Re: Objections to Proposal to Redevelop Stabling DA 871/2010

We have strong objections to the proposed stable precinct development at Randwick Racecourse. Our chief concerns are;

ELEVATIONS - STABLE BLOCK
 STABLES & TRAINING FACILITIES
AJC RANDWICK RACECOURSE

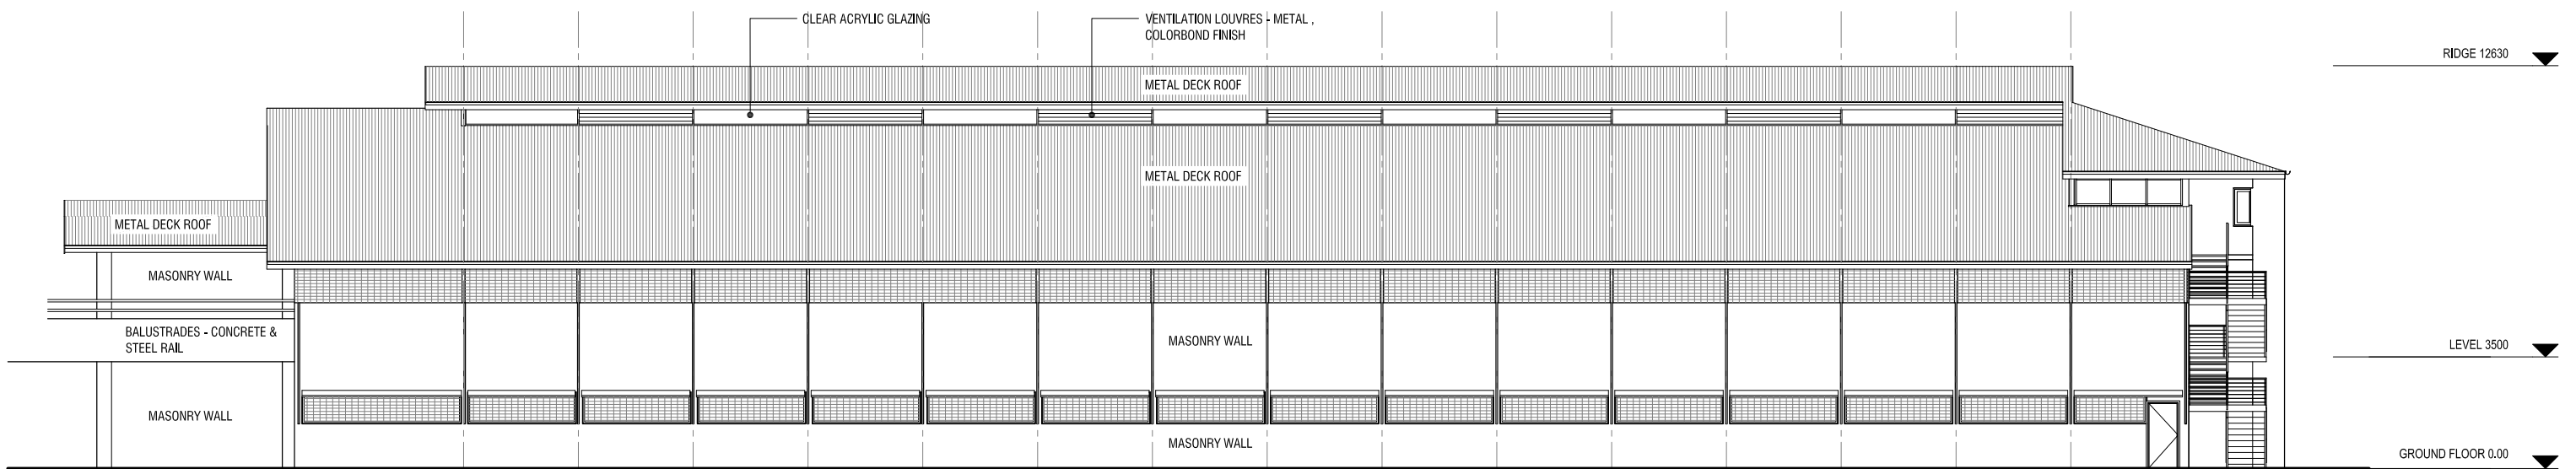
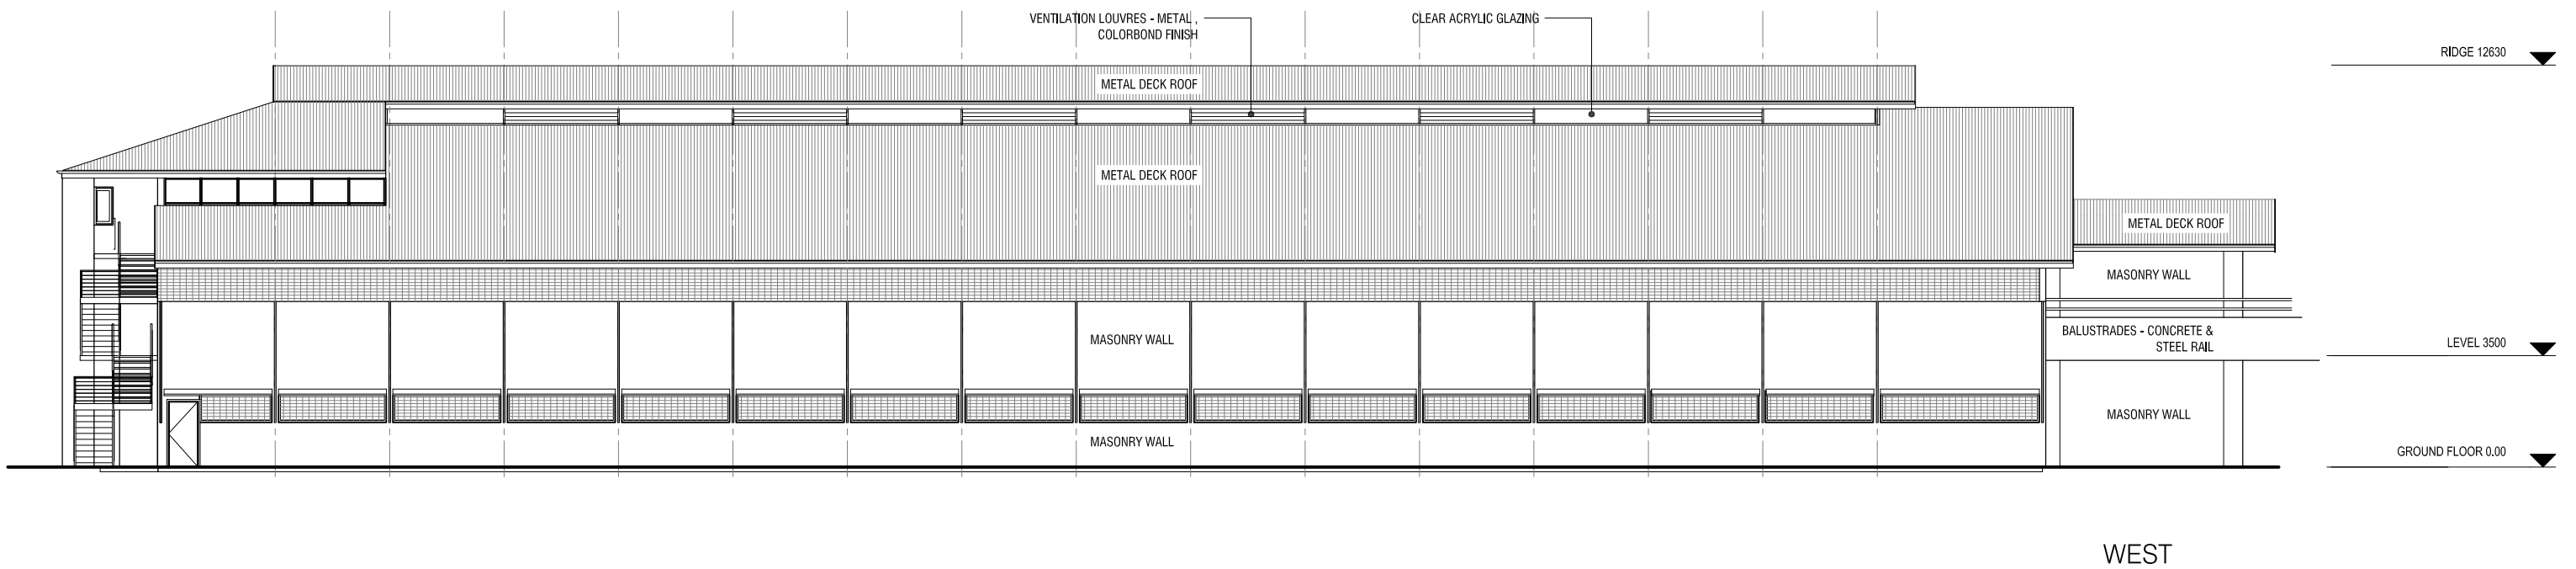
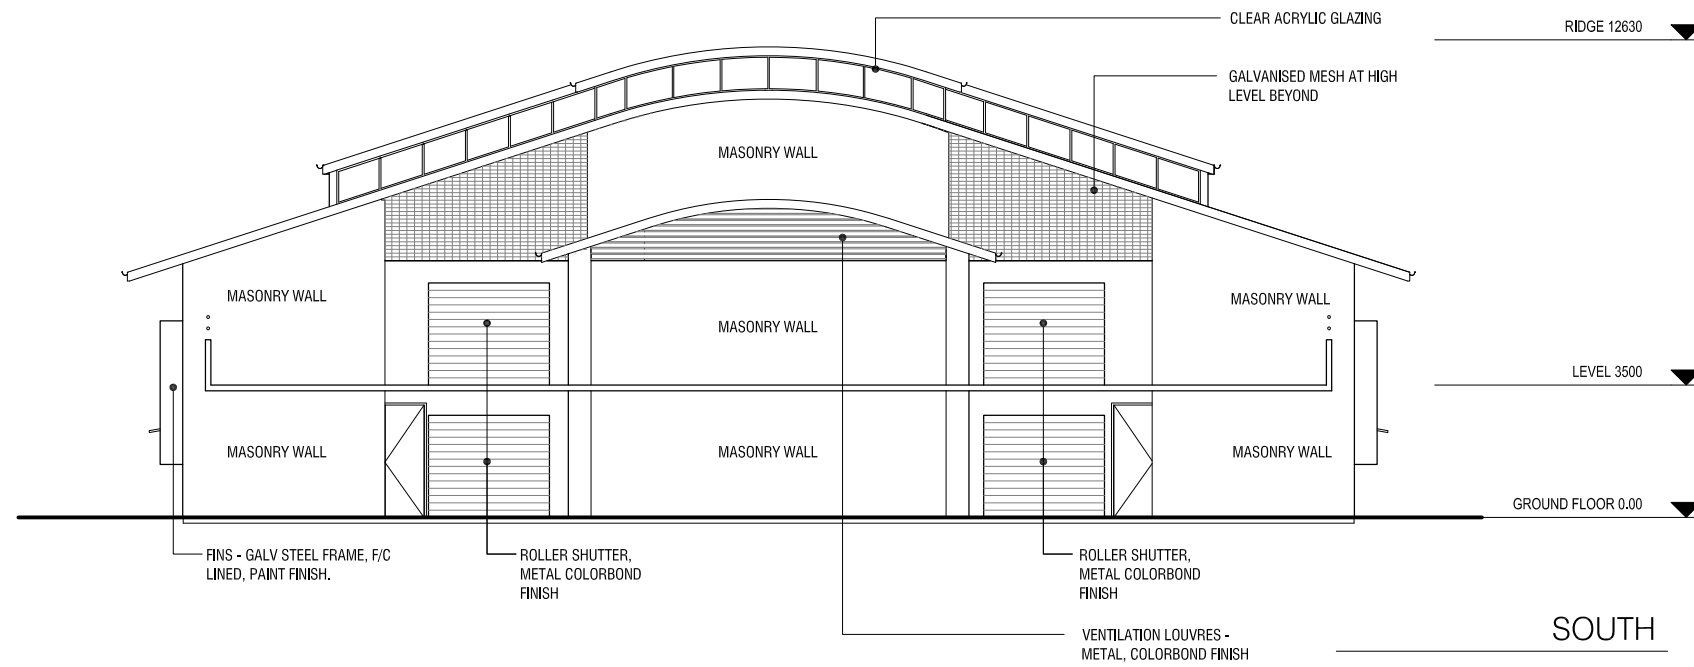
The description of the six barn style buildings as 'two' storey is misleading as they are the height equivalent of almost four residential storeys. Six four storey buildings along with a one hundred place plus carpark and at least a further twelve two storey buildings will result in a massive loss of outlook for nearby residents.

The proposed height of the development should be reduced.
